Rezoning Transportation Analysis

Petition Number: 2021-186

Date	Description
12-28-21	First Review (TNM)
01-27-22	Second Review (PDM)
02-24-22	Third Review (TNM)
03-30-22	Fourth Review (PDM)

EX01  
SHEET

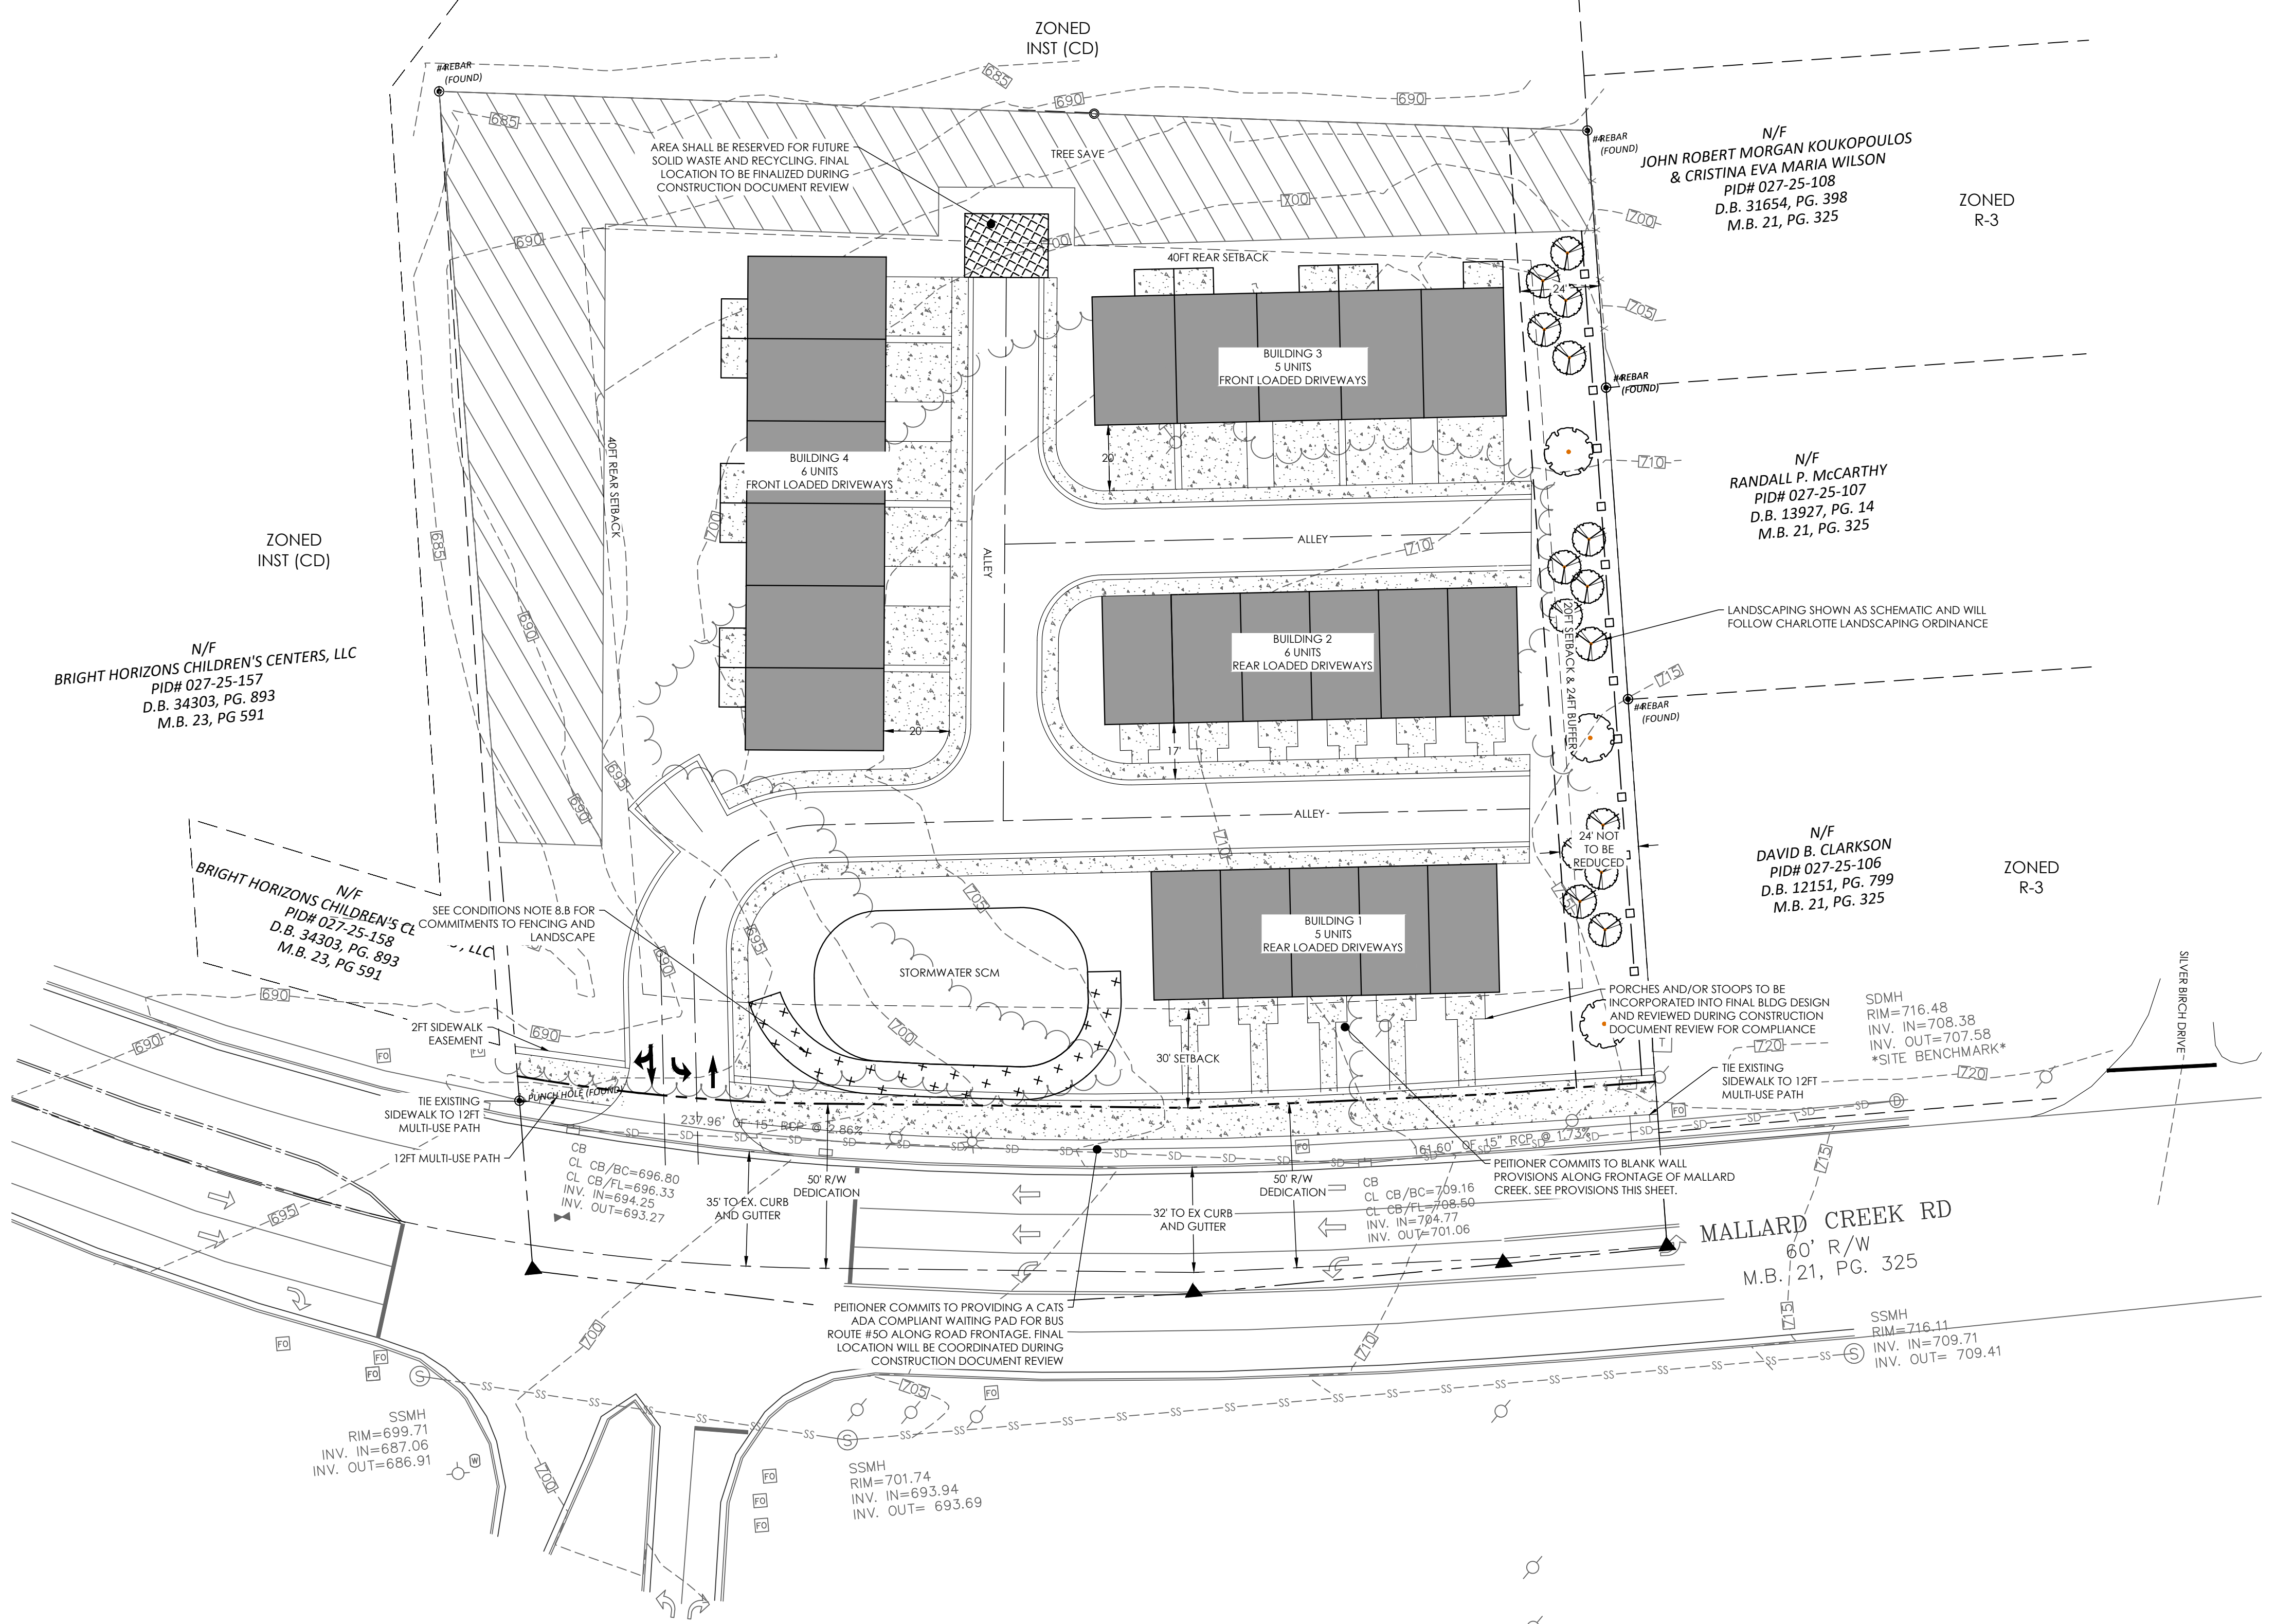
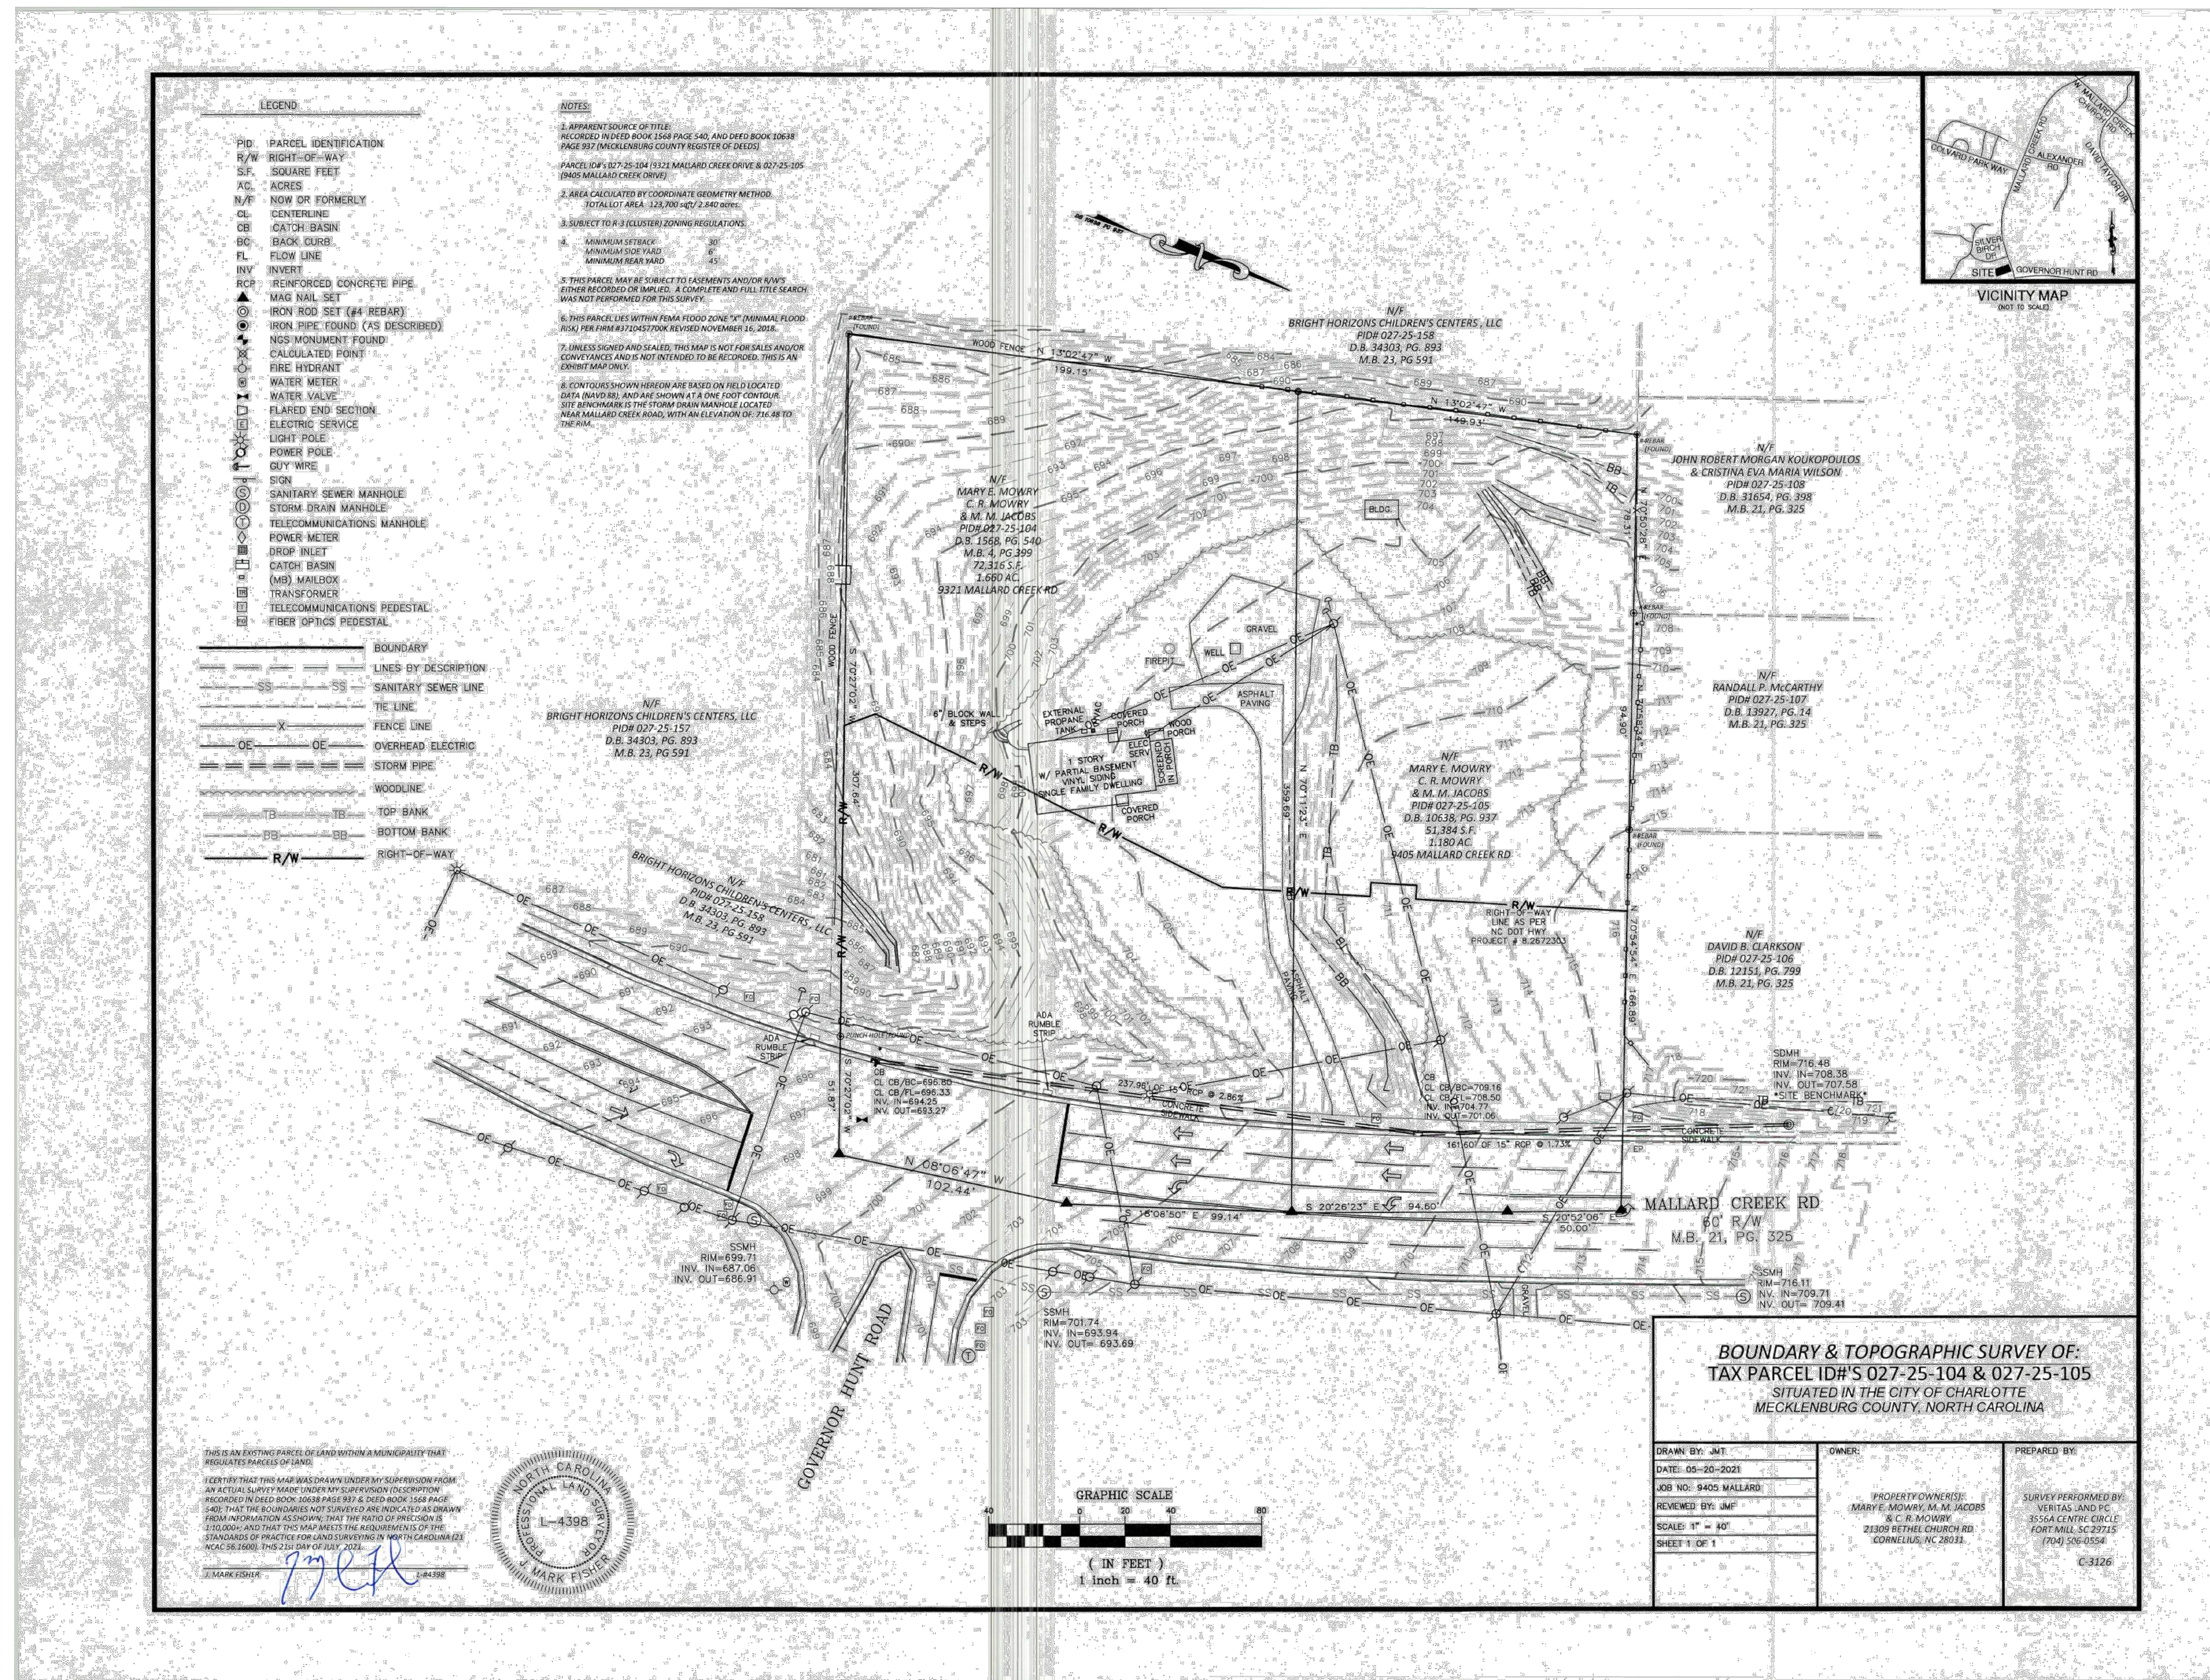
Outstanding Comment from 01.27.2022: Label and dimension the curb and gutter from the centerline for each road on the site plan.

Clarifying Comment from 01.27.2022: Median needs to be designed to allow for a minimum of 150ft of full width storage for the Mallard Creek left turn lane at Governor Hunt. Show 150ft of full width (11ft) storage. A conditional note specifying the requirement of the 150ft of full width storage and the concrete median should be added to provide clarification.

Clarifying Comment from 01.27.2022: Driveway radius needs to tie into the curb line at a tangent.

~~11. Outstanding Comment from 02.24.2022:~~ Proposed 12 ft multi-use path along Mallard Creek Rd should extend the entire property frontage per Ch 19. SUE is required 2ft behind multi-use path if located outside of the 50ft dedicated ROW for future maintenance.

~~Clarifying Comment from 02.24.2022:~~ CDOT requests a 12ft multi-use path along Mallard Creek Rd. The 6 ft sidewalk as proposed is required per Chapter 19. The wider sidewalk is in conformance with the Charlotte WALKS and BIKES policy. Revise the site plan to show sidewalk utility easement 2-ft behind the sidewalk if located outside of the ROW. Site plan revisions are also required to show the sidewalk tie in at the property line. Add a conditional note committing to the 8-ft planting strip and 6-ft sidewalk.
